City of Albuquerque
Stormwater, Erosion, and Sediment Control
Construction Site Inspection Report

ESC File #:	M14E038	Project Name:	Love's BP
ABQ-PLAN #:	SWQ-2025-00042	Project Address:	3200 Broadway Blvd SE
NPDES ID #:	NMR1006RE / 6AW	Inspection Type:	Follow-up
3/25/2026	Owner		Contractor
Operator:	ABQ Terminal LLC	Harris United	
Contact Name:	Spencer Haines	John Arenz	
Contact e-mail:	michelle.wright@loves.com	john@harrisunited.com	
Contact Phone:	405-847-5297	918-500-6678

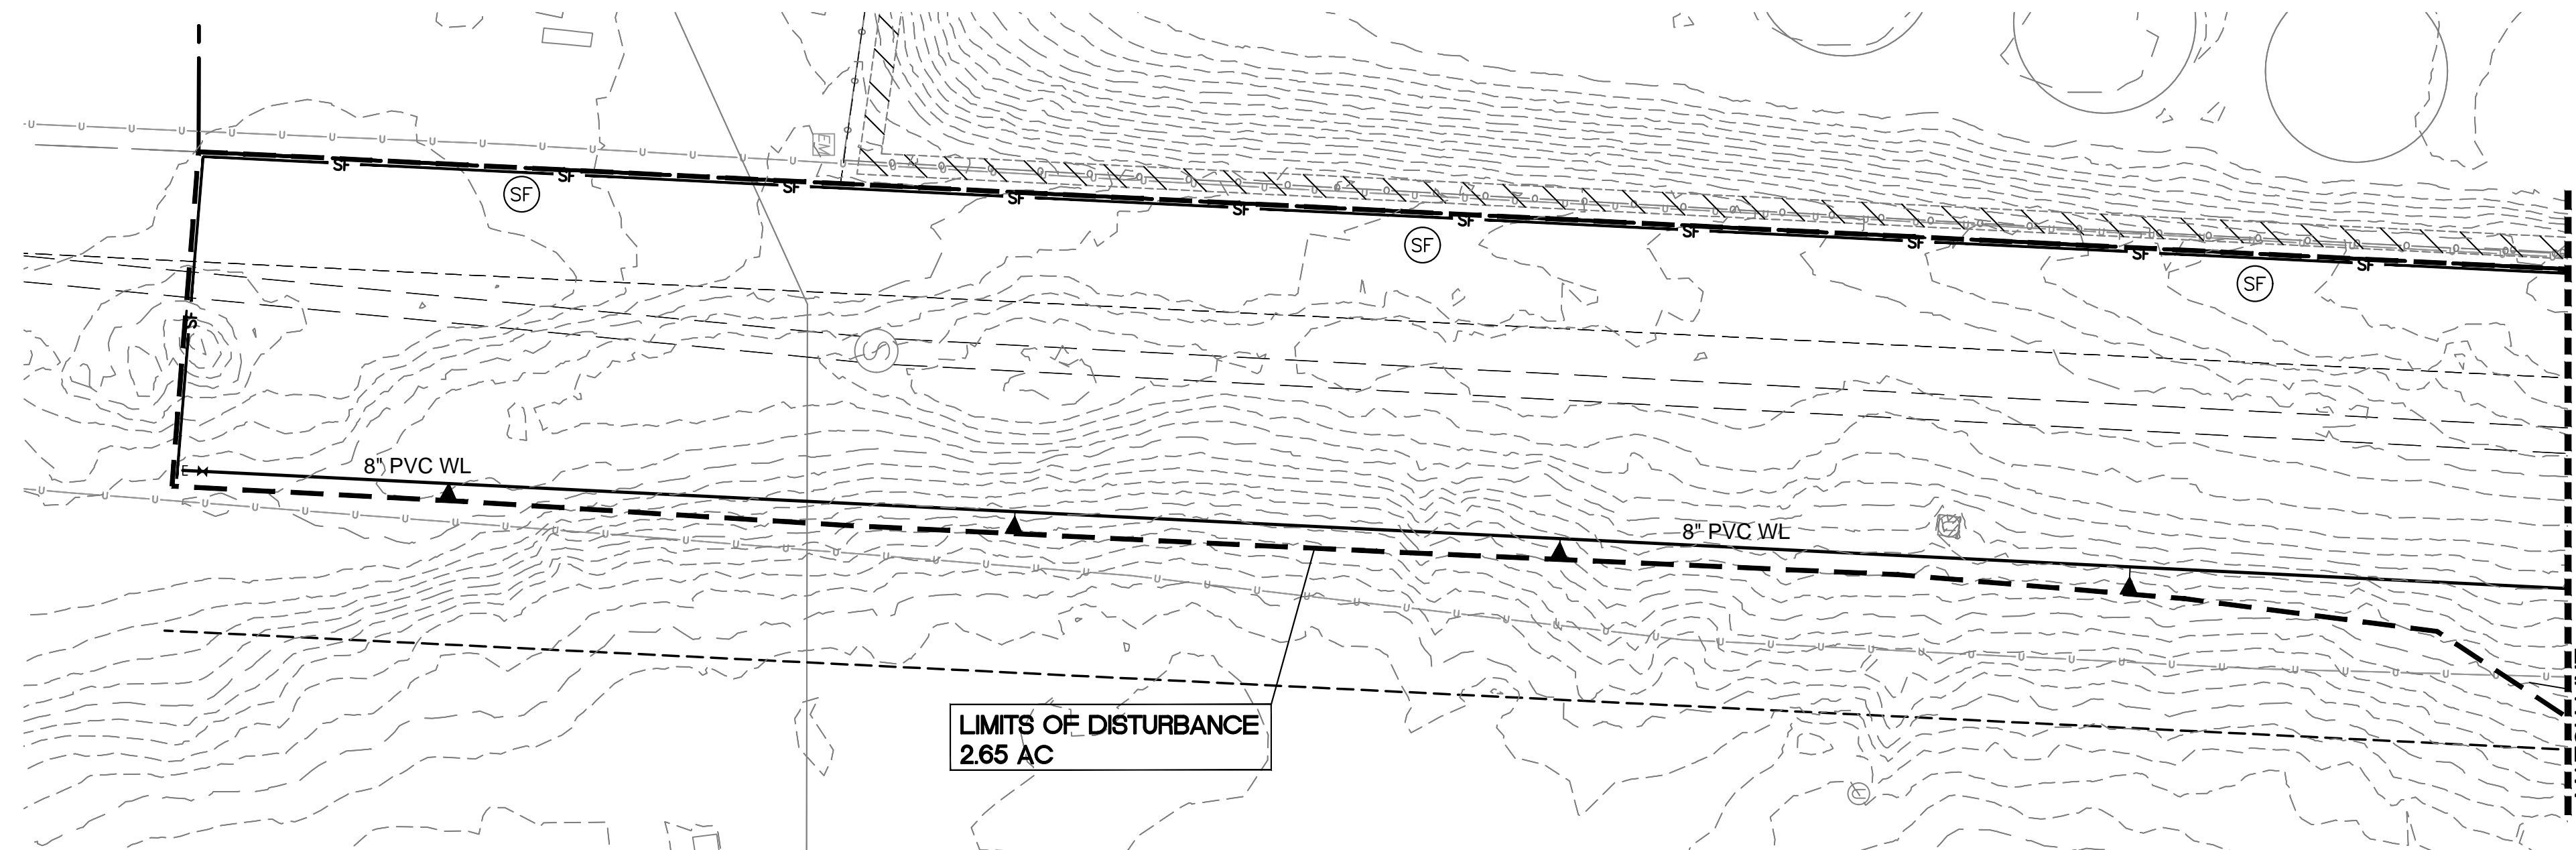
Item #	Violation Category	Deficiency/Corrective Action
1	SWPPP	The submitted addition to the ESC Plan is still missing the land disturbances on and stabilization measures for the neighboring property east of Arno St in violation of CGP Parts 7.2.4 and 7.2.6.b.vii. A washout pit and some piles of debris were discovered south of the end of Arno St pavement that was not marked on any available map, also in violation of CGP Part 7.2.4. The City's field measurements show land disturbances extend approximately 60 ft from the paved edge of Arno St, but the ESC Plan shows only approximately 30 ft of land disturbance east of the paved surface. Also, the submitted map shows the limits of disturbance only for the Arno St construction, not the full construction area, including the northwestern pond, which still requires stabilization measures. Required mitigation: As stated in CGP Part 7.2.4, include a legible map, or series of maps, showing locations where earth-disturbing activities will occur, approximate slopes before and after major grading activities (note any steep slopes), and locations of on-site and off-site construction support activity areas. According to CGP Part 7.2.6.vii, the SWPPP must include the specific vegetative and/or non-vegetative stabilization measures along with the deadline that will be met in accordance with CGP Part 2.2.14.

Not only is the 40-foot encroachment onto the neighbor's property not shown on the latest map, but the NOI for that property owner is also missing. If that entire area is immediately stabilized with native seed and aggregate mulch per City Spec 1012, then the requirement to display the area on the SWPPP Map and file that property owner's NOI becomes unnecessary.

There is an additional area of disturbance on ABQ Terminal LLC's property between their fence and the Arno St ROW that must be added to the SWPPP map and be included in the Notice of Termination when filed with the EPA.

Native seed and Hydro-mulch per City Spec 1012 does not satisfy the Final Stabilization Criteria for CGP Part 2.2.14.c. However Native seed with aggregate mulch per City Spec 1012 meets that criterion immediately after application and is acceptable within the City ROW.
